From: Laura Gibbons [REDACTED]
Sent: 24 June 2020 08:26
To: Planning.Responses <Planning.Responses@arun.gov.uk>
Cc: Anita Gardner <Anita.Gardner@arun.gov.uk>
Subject: A/79/20/DOC- The Laurels, Dappers Lane

Condition 14- surface water drainage design

TITLE Proposed Drainage Layout and Levels Plan

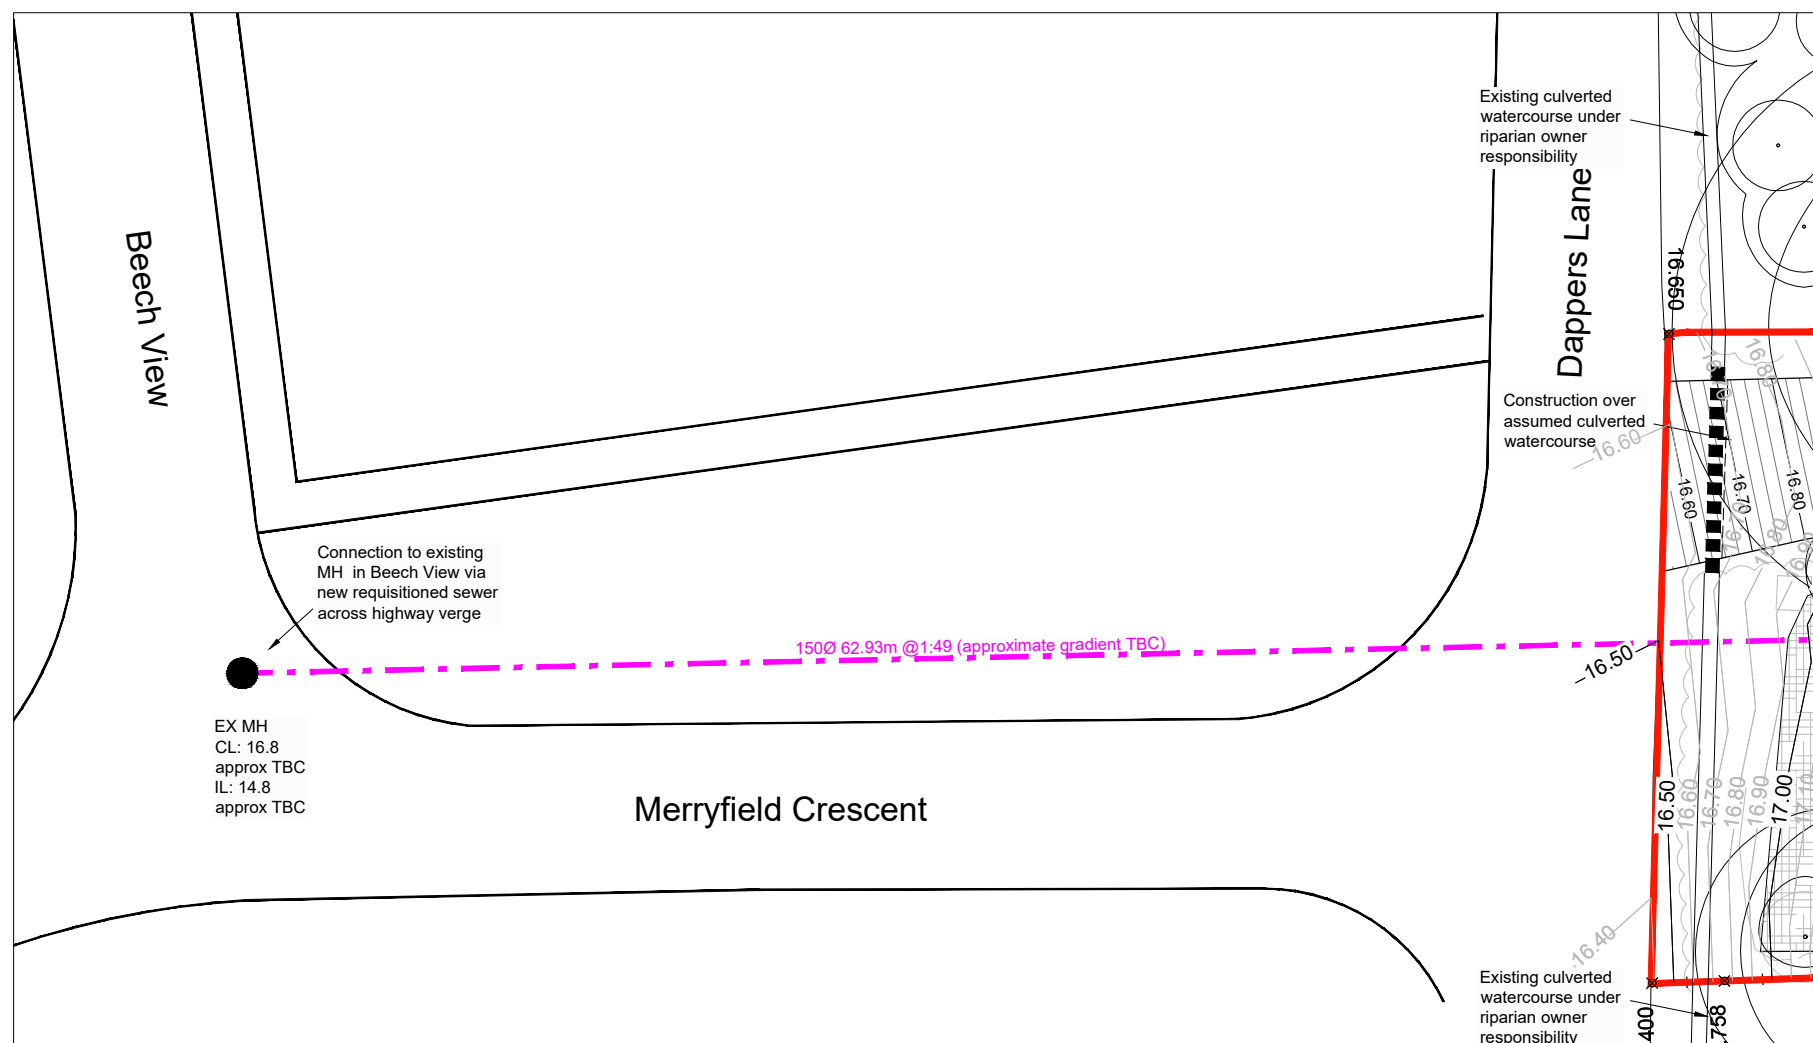
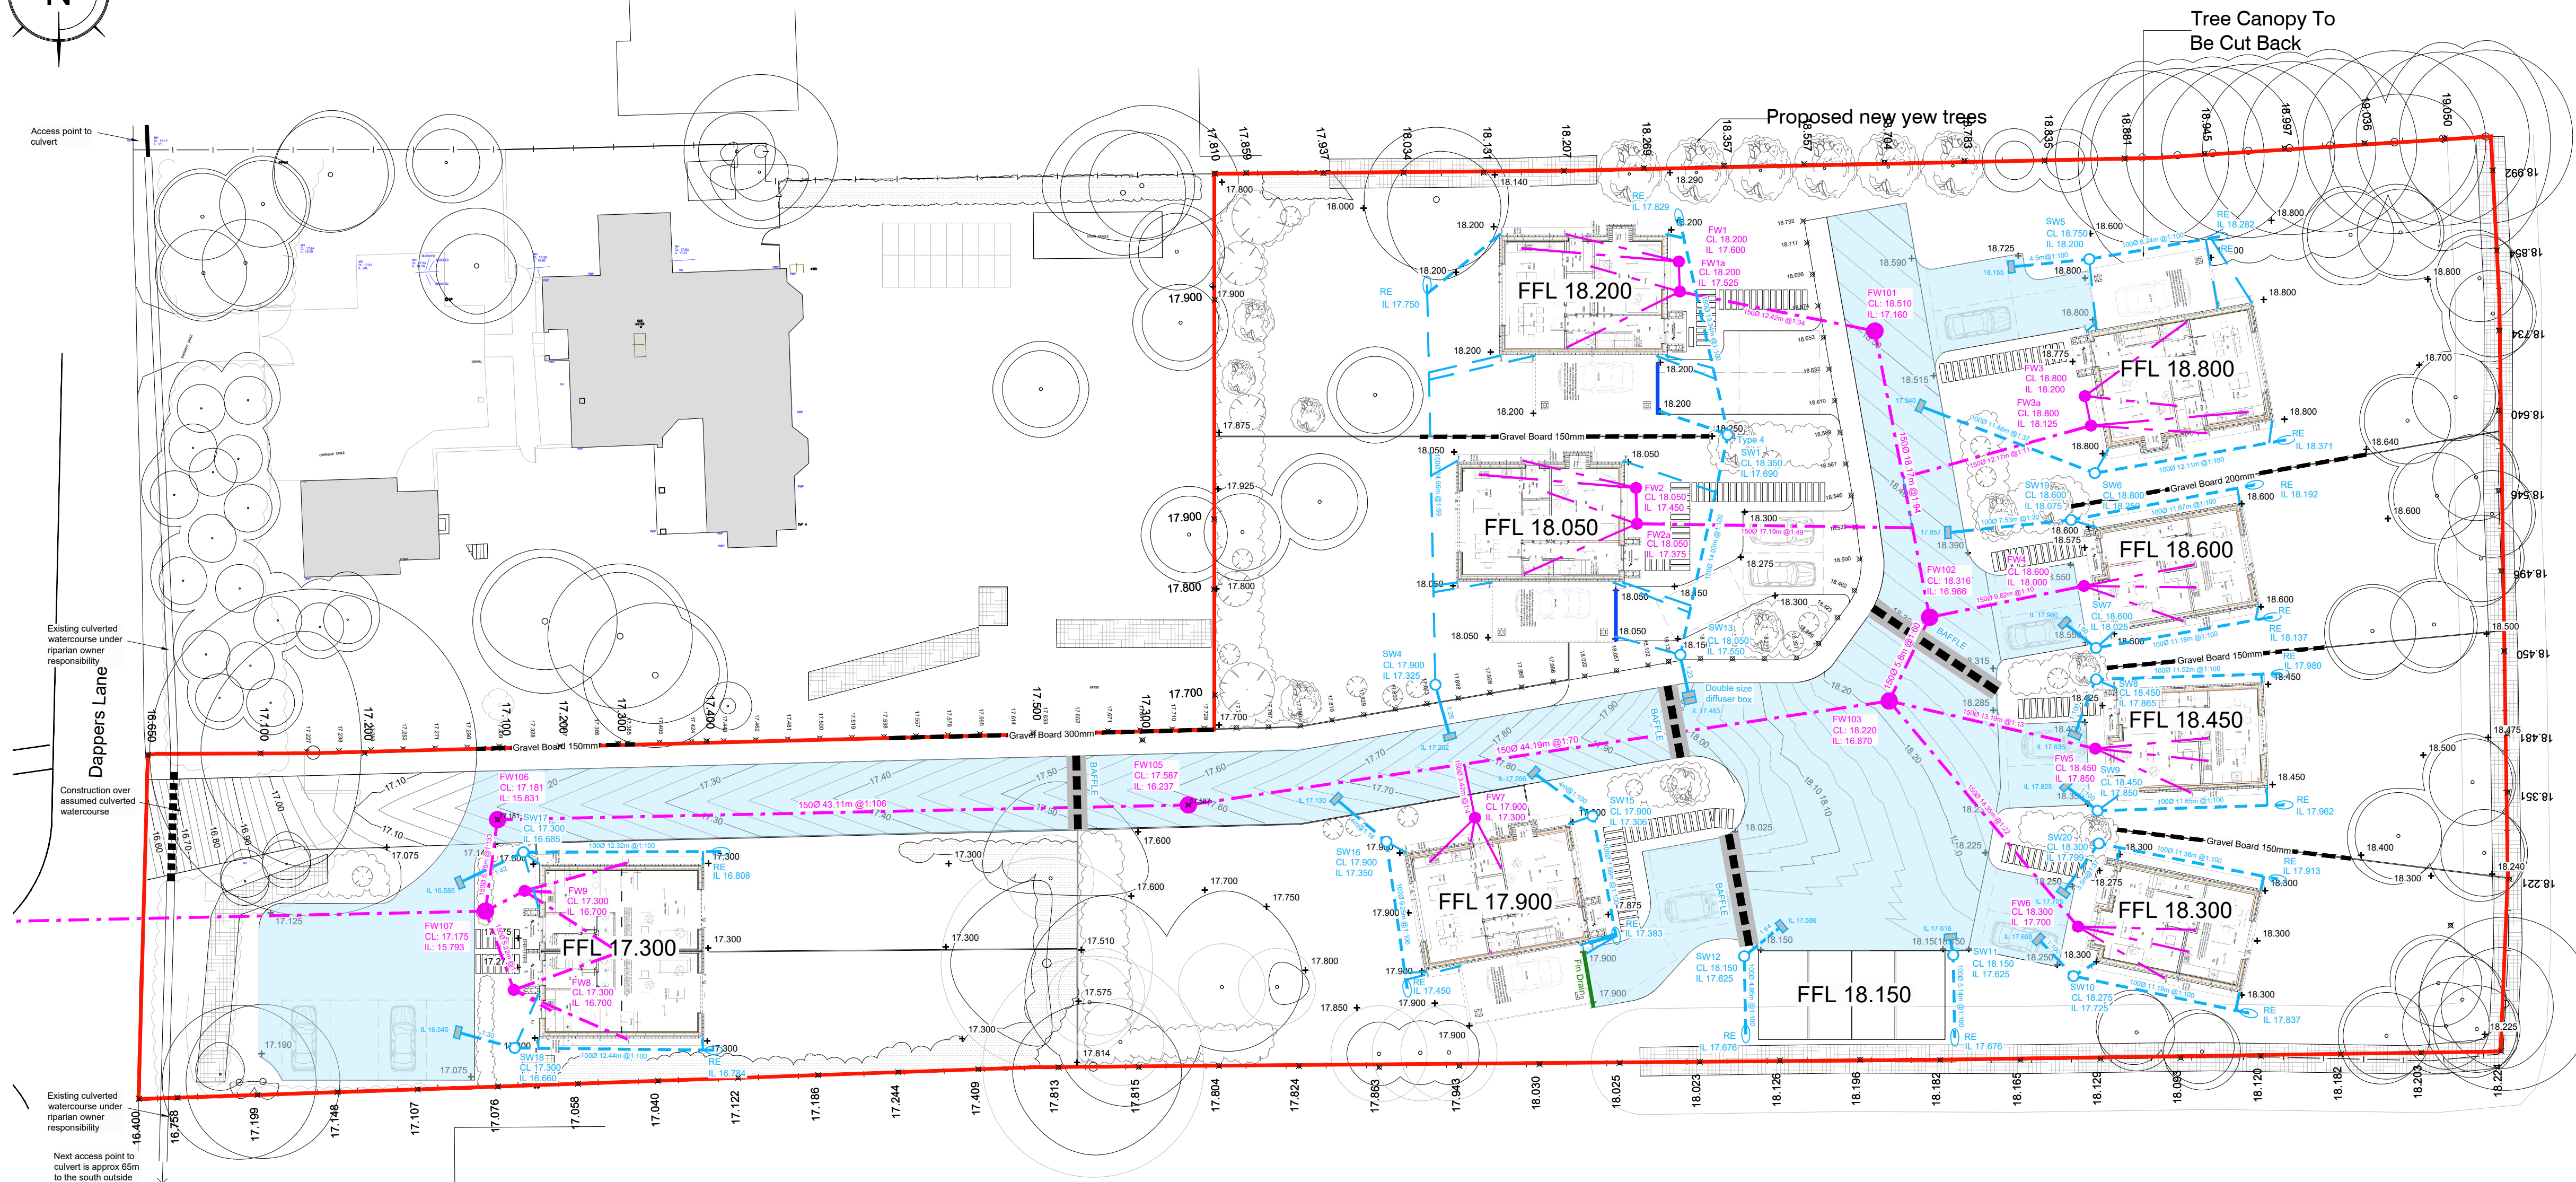
1. Please include a baffle at the boundary of catchment A and C. Without this there is a risk water will continue on downslope and end up in Dappers Lane.
2. Why have permeable paving areas been modelled as infiltration blankets rather than permeable paving structures? As a result of this slopes have not been modelled, this is unacceptable. Either adjust calculations or add more baffles.
3. Please detail depth of permeable blocks.

Table 2: Drainage System Maintenance Summary

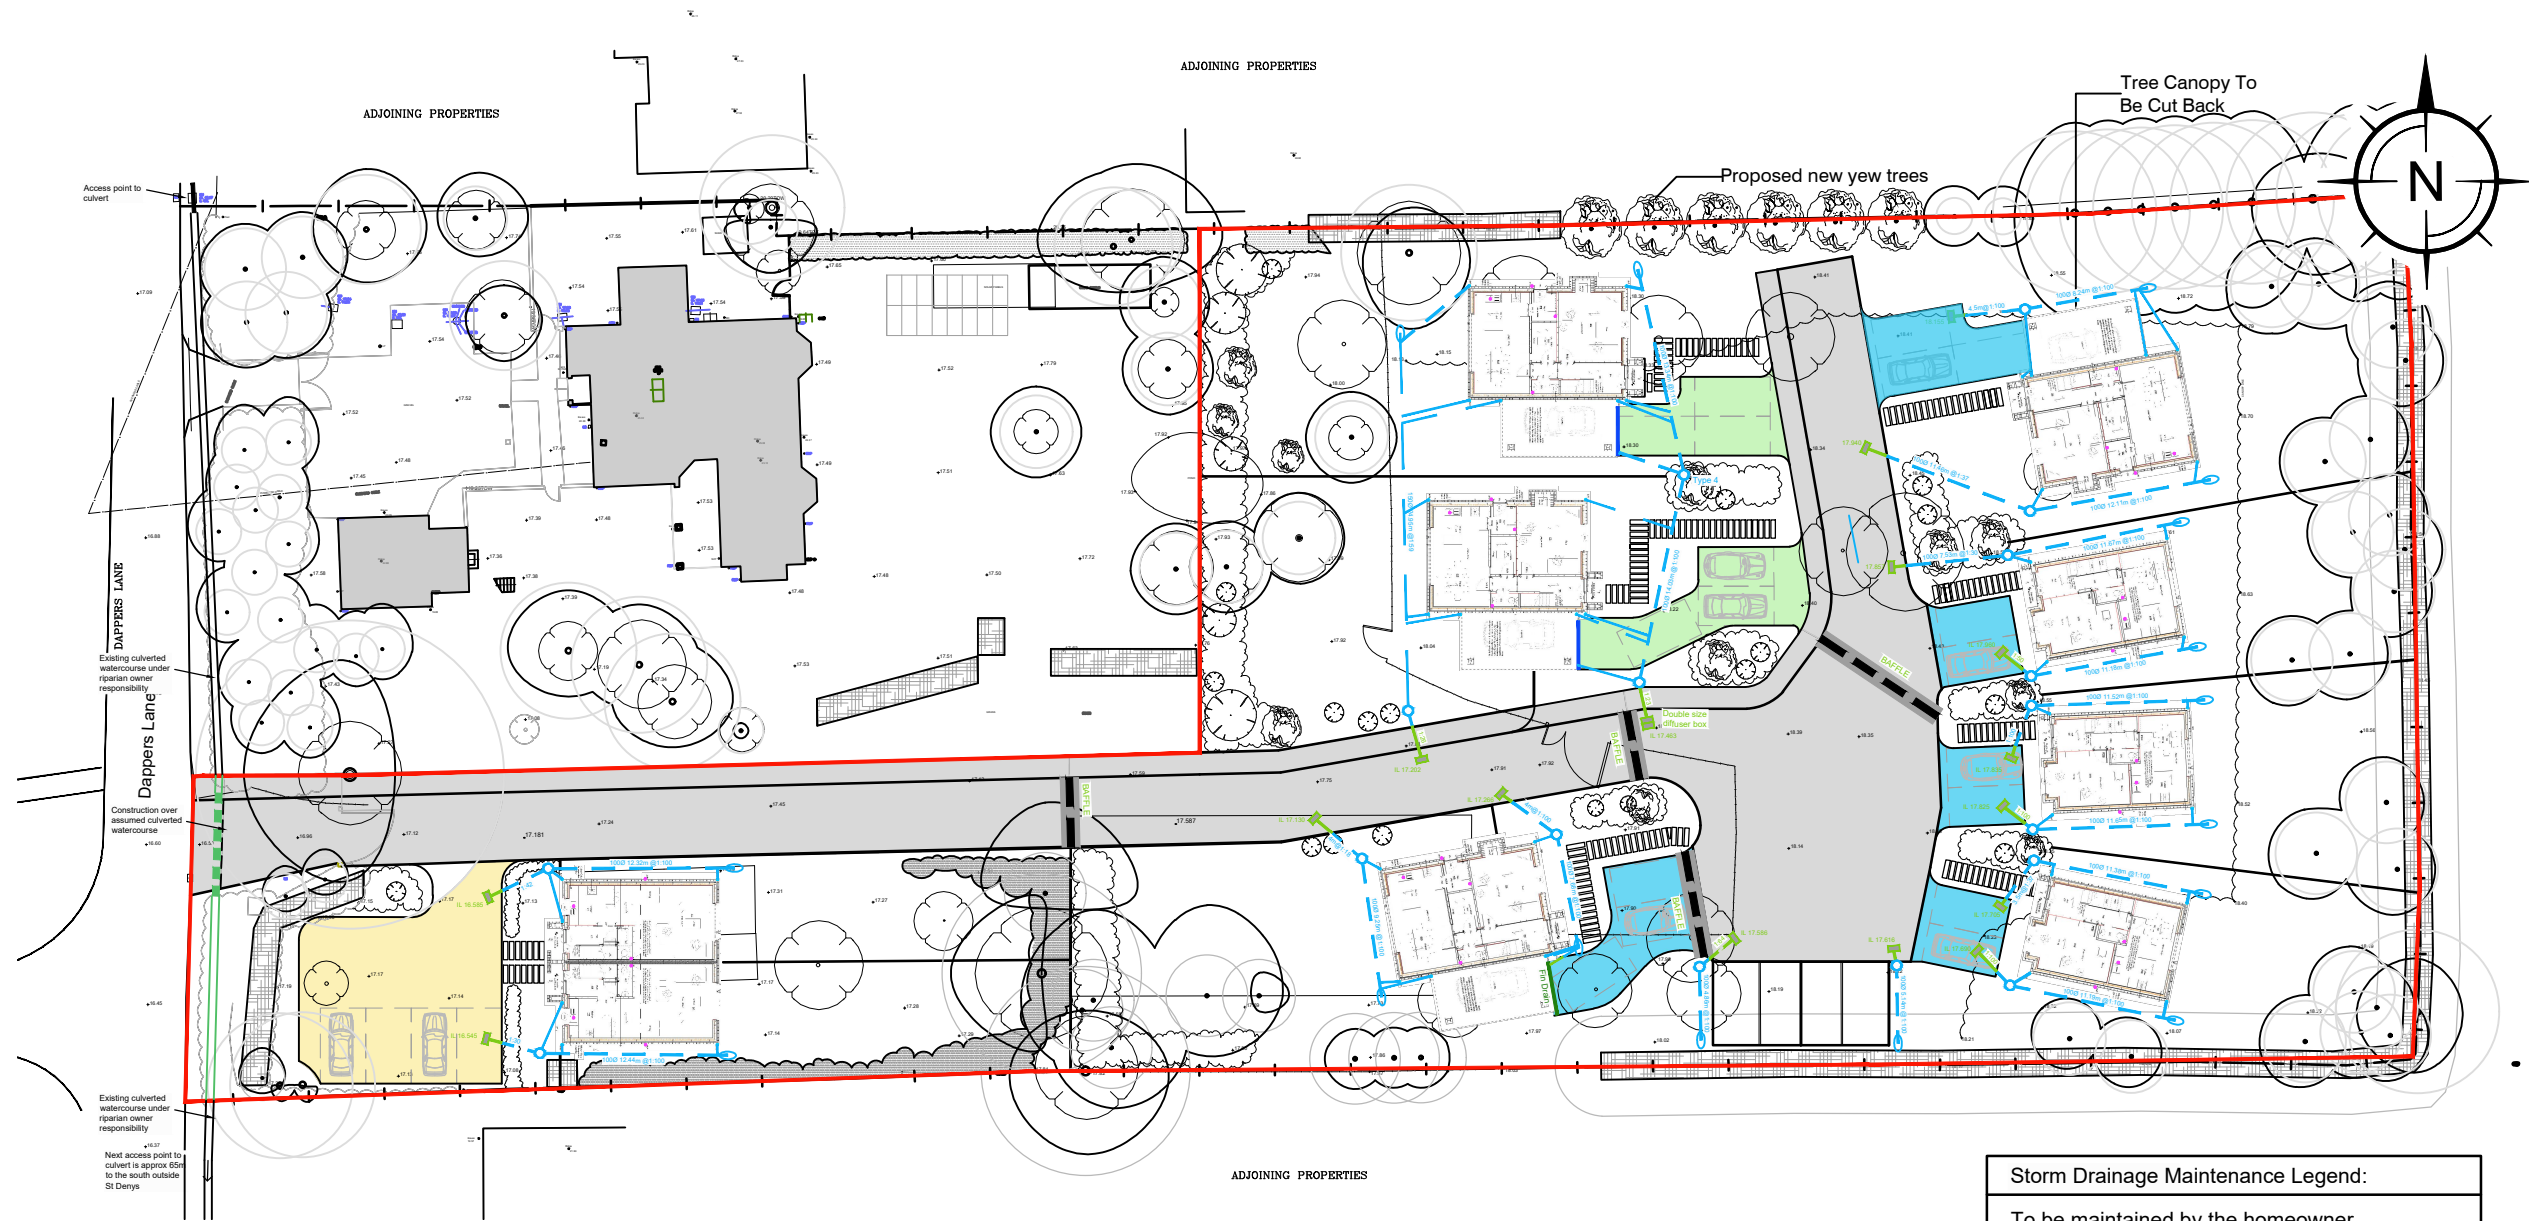
Table 2 does not fully tally with table 1.
